20 September 2022

### 2210545

# **Appendix A – Response to Submissions**

Extracts from public authority submissions and submissions from organisations, including stakeholder and interest groups, received in relation to SSD-32927319 and a response to each of these matters has been provided in the sections below.

Project No.	2138	Scale @ A2	1 : 500
	Date	SEPT 2022	Co-Ord	
	Dwnn	CT	Chck	MB
Drawing Status		FOR APPROVAL		
Drawing No.			Revision	
AR 0500			10

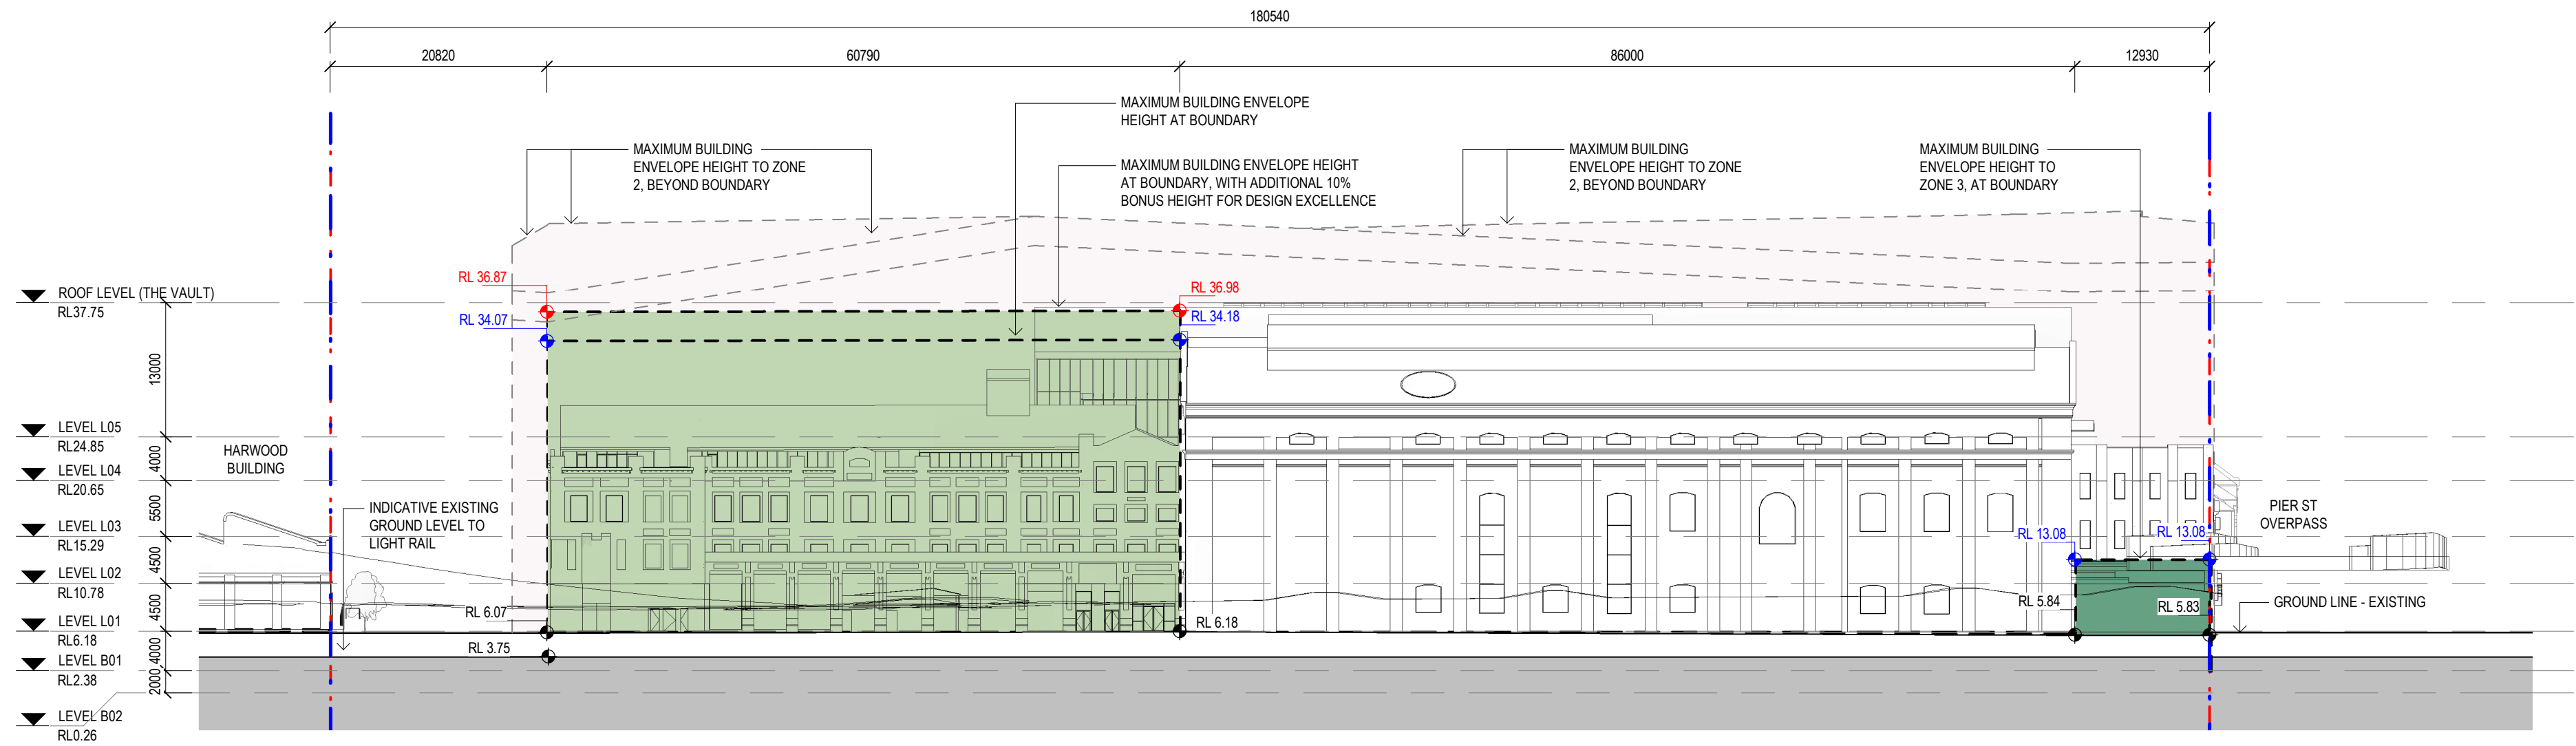
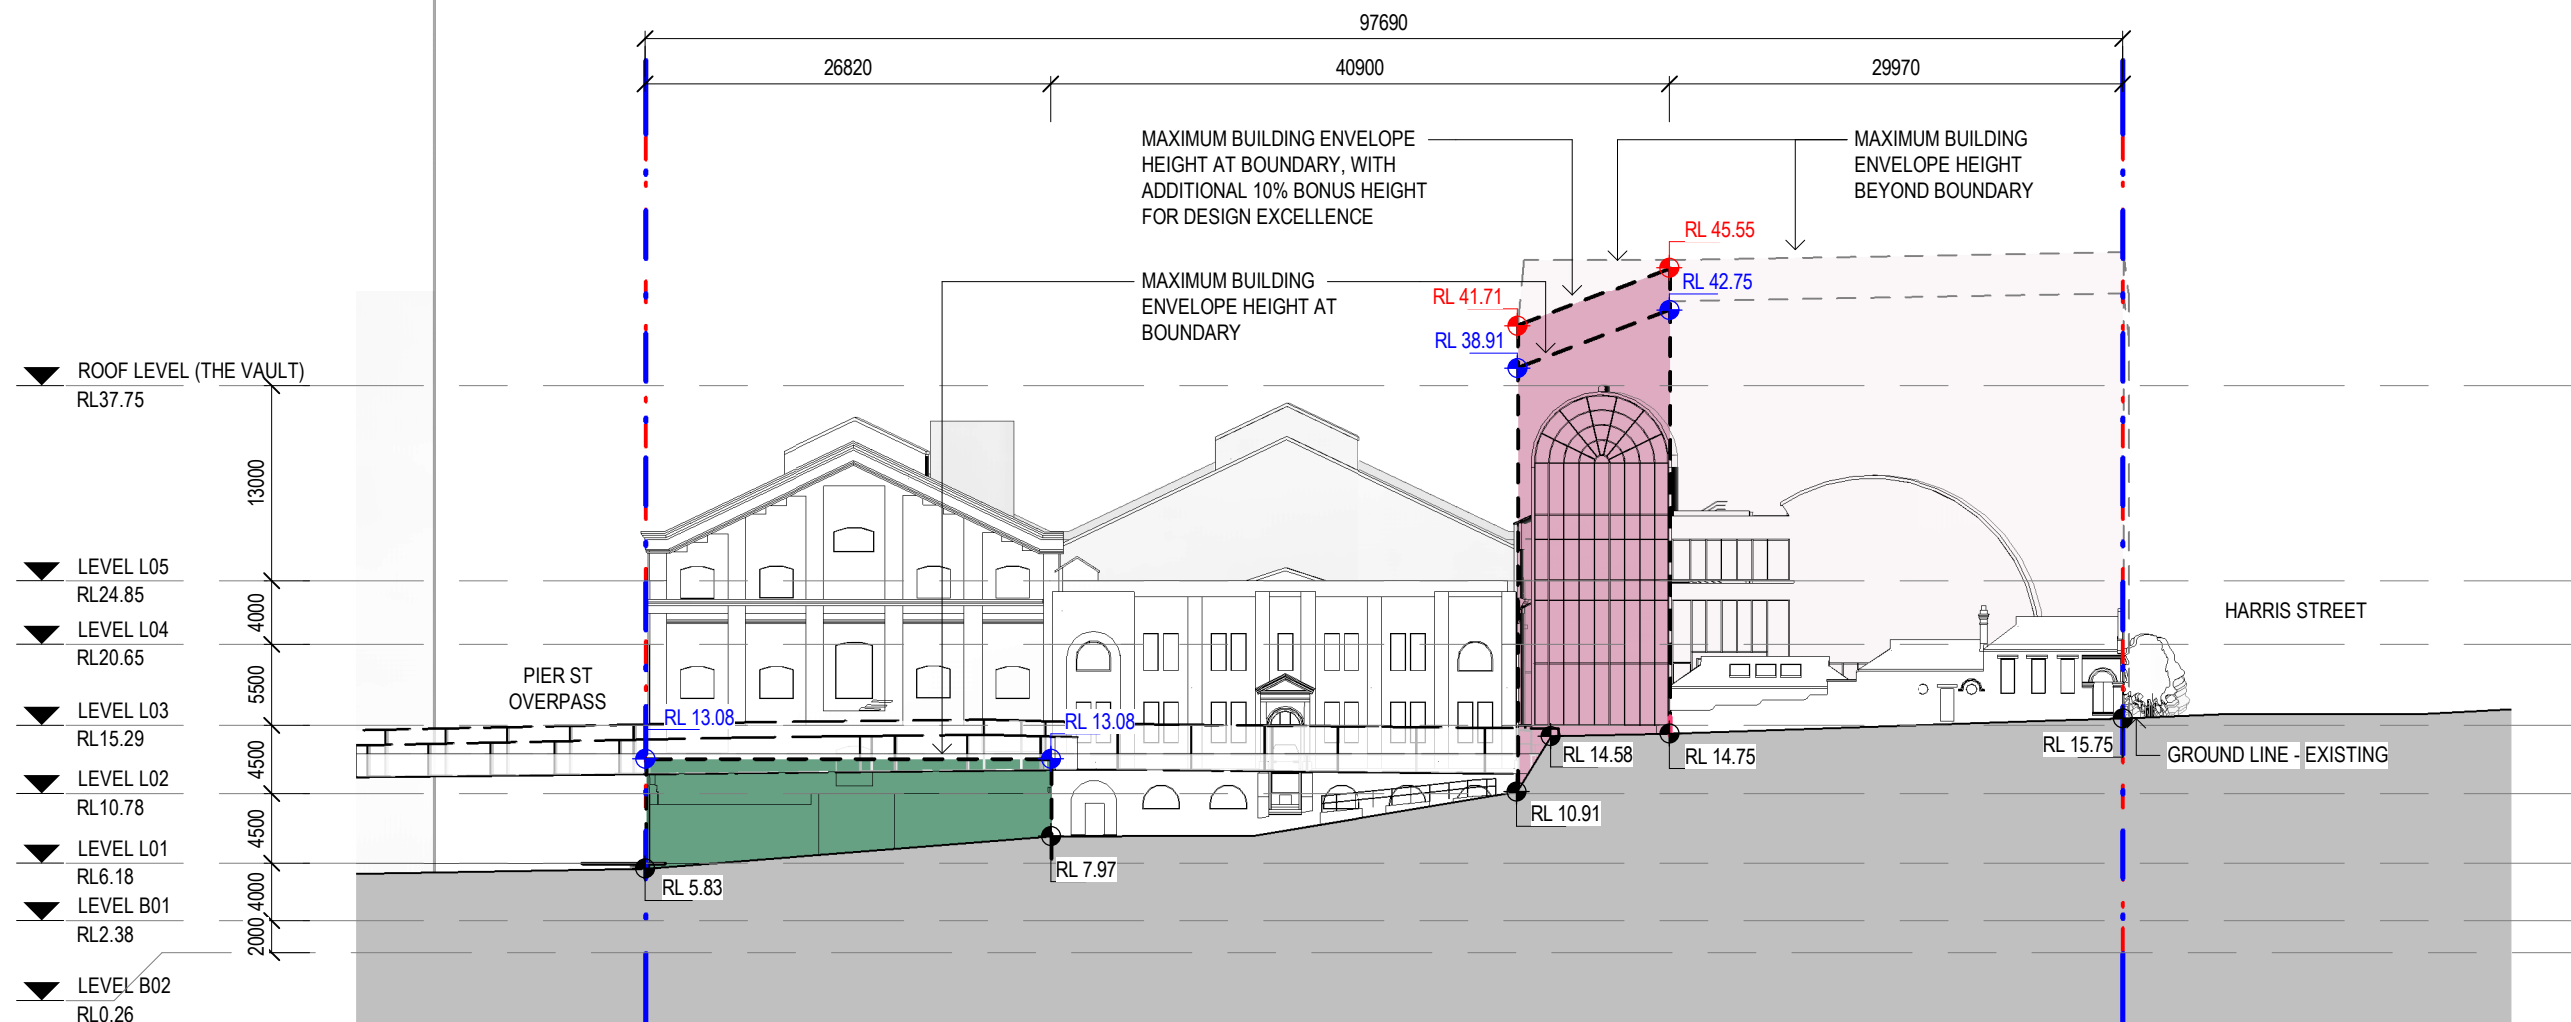
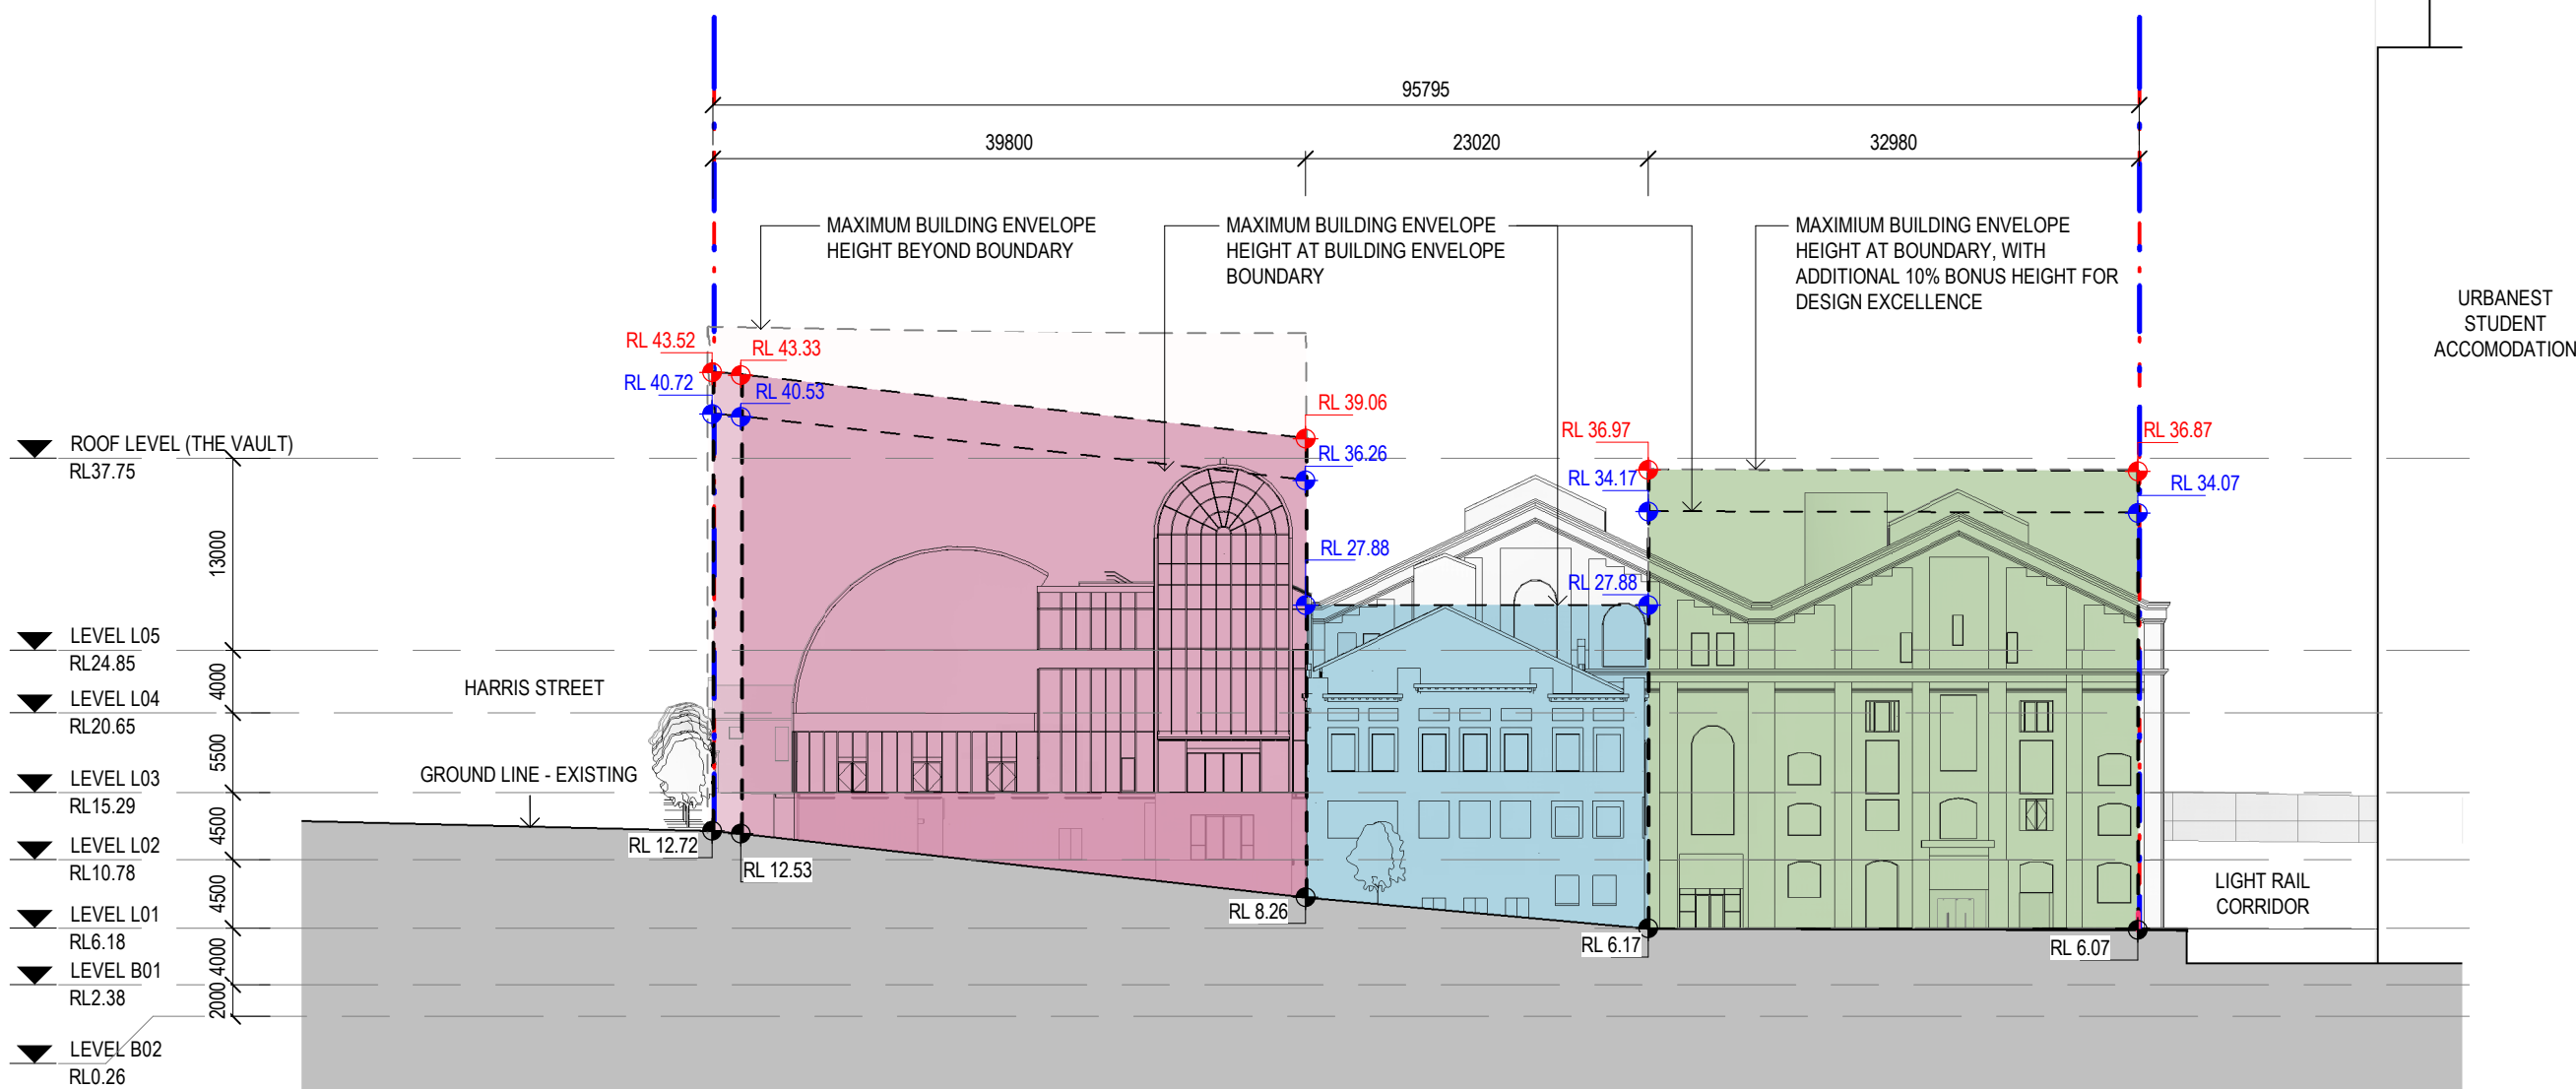
The submitted building envelope and massing drawings provides a series of coloured planning envelopes across the site. While envelopes surrounding and above items of no heritage significance are understood, clarification is sought as to why planning envelopes are identified above the existing heritage listed items. Whilst the envelopes above the heritage items only extend to or just above the existing heights of the buildings, clarity is needed as to the purpose of the inclusion of a planning envelope above the original roof form of the heritage listed buildings. Is development permitted or anticipated above the heritage listed buildings, or this is a tool to differentiate those envelopes where height can or cannot be explored. The City assumes that the heritage items being of local and state significance shall be retained in their current form and any development above their roof is to be avoided. Separate to this observation, the City has previously discussed with the Powerhouse forthcoming amendments to the LEP to allow the Powerhouse site(s) to be potentially eligible for an award of heritage floor space for its conserved heritage listed buildings. To be eligible for an award of HFS in the future, the heritage listed buildings should not be subject to works that would increase the external envelope and floor space of the building other than a minor increase to facilitate the adaptive re-use of the heritage building.

-7 principles against which a Design Excellence Strategy can respond. The submitted principles, objectives and guidelines are very general and loose as to not have meaning or something to respond to. The application needs clarification regarding the proposed building envelopes around existing State heritage items. Envelopes should be amended or annotated to remove doubt of any possible infill of the existing roof forms of the heritage listed buildings. Alternatively, possible building envelopes above existing heritage items should be removed from the drawings entirely.

above the Heritage Core and Former Post Office State heritage items have been removed, except for a reduced envelope above the Switch House in the location of the existing modern rooftop/mezzanine location. The purpose of this amendment is to make clear that no new buildings are proposed in these locations to protect the heritage values of these items, consistent with the Conservation Management Plan.

Noted, refer to the updated Urban Design Guidelines provided at Appendix D and Building Envelope Drawings provided at Appendix C.

Figure Ground Plan

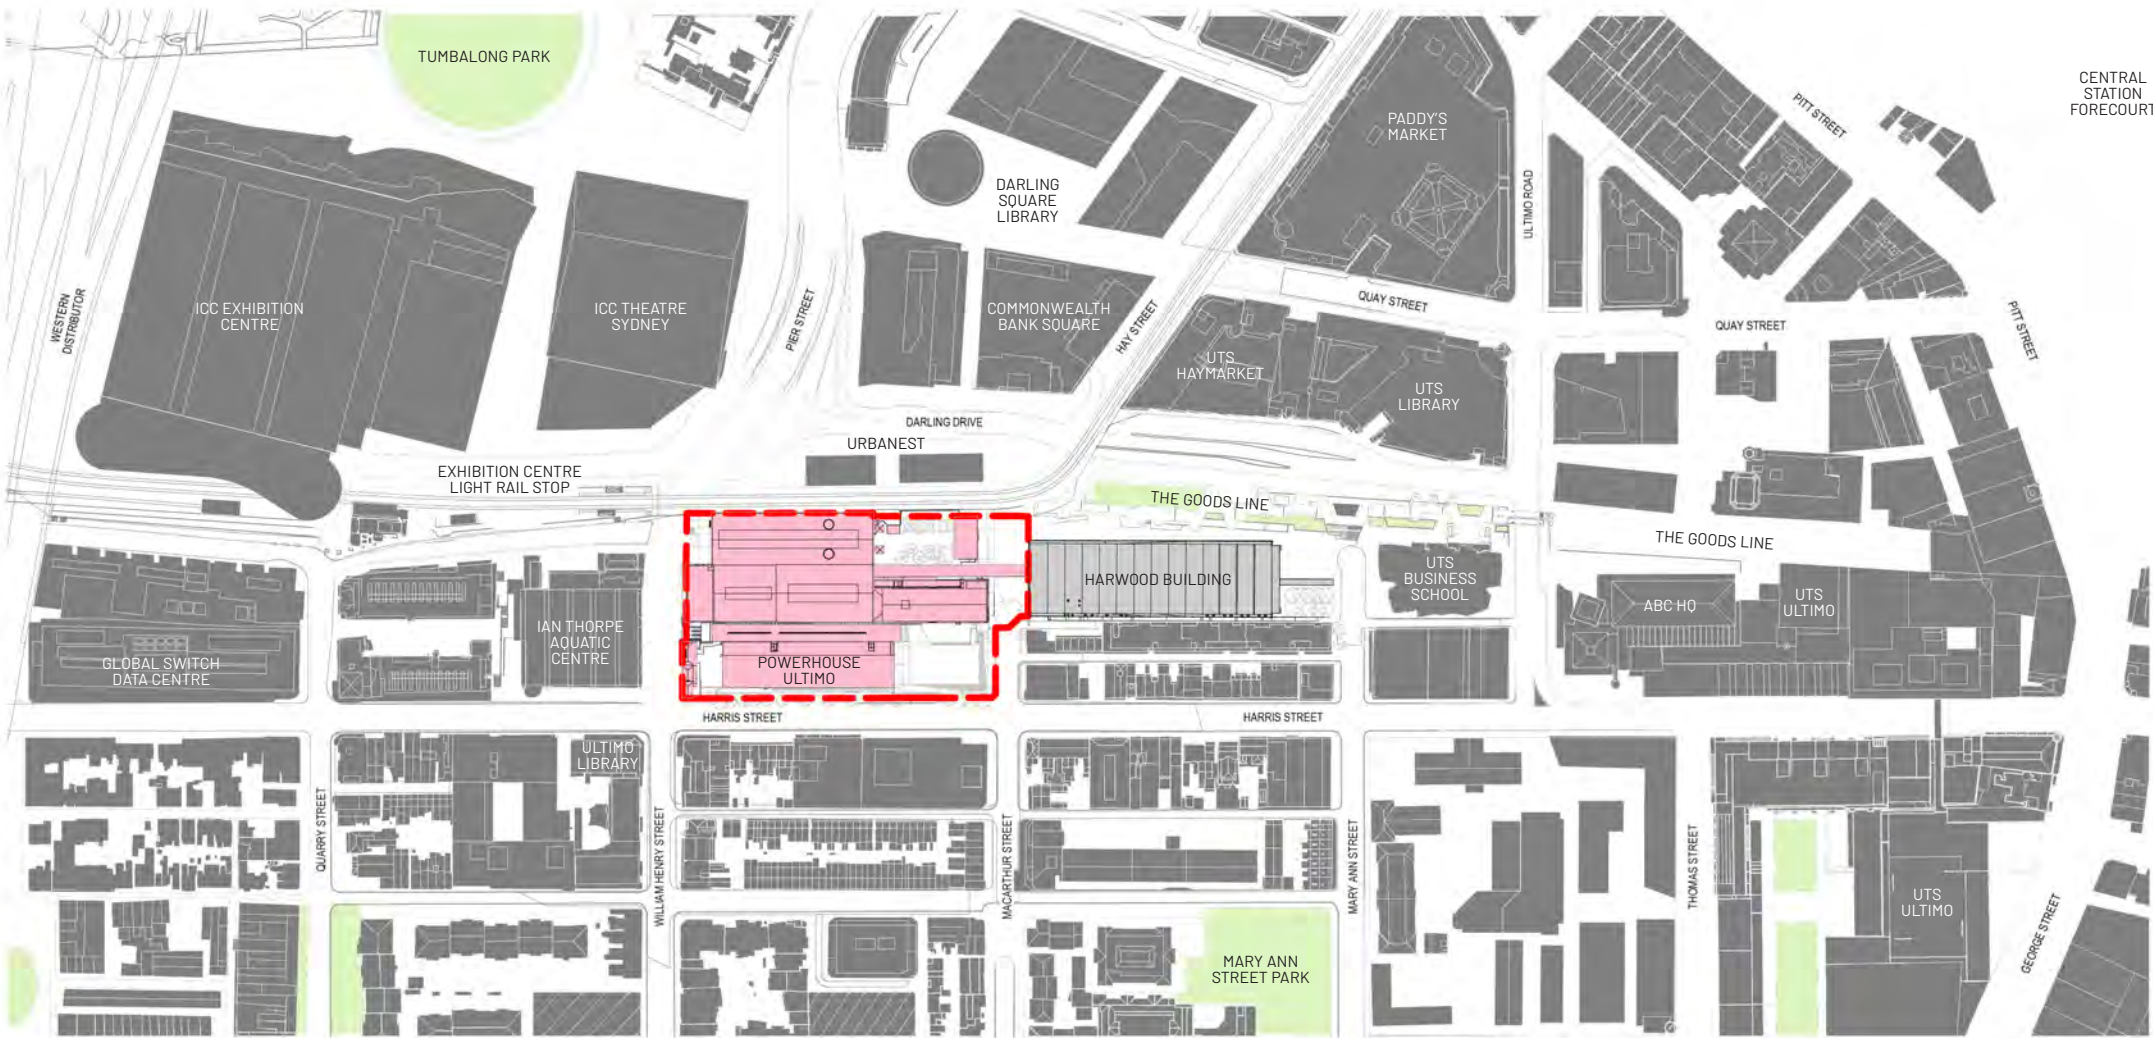
- A figure ground drawing of Harris Street with all the streets surrounding the site relating to transport, civic buildings and spaces, the street wall height of Harris Street. This is to understand the spatial structure of the site within the immediate precinct, including the gradients and levels. An elevation of the buildings on the opposite side of the streets around the site of Harris Street. Justification for introducing a non-continuous vertical setback above on Harris Street and MacArthur Street if it is to remain, although this aspect is not supported by the City.

A figure ground drawing has been developed and is included in the updated urban design analysis. The drawing clearly demonstrates the disparate development patterns surrounding the Powerhouse site. This is supported by further elevational analysis that clearly demonstrates a varying street wall heights and development patterns throughout the area. Further the sectional analysis outlines how the topography of the area has influenced development patterns.
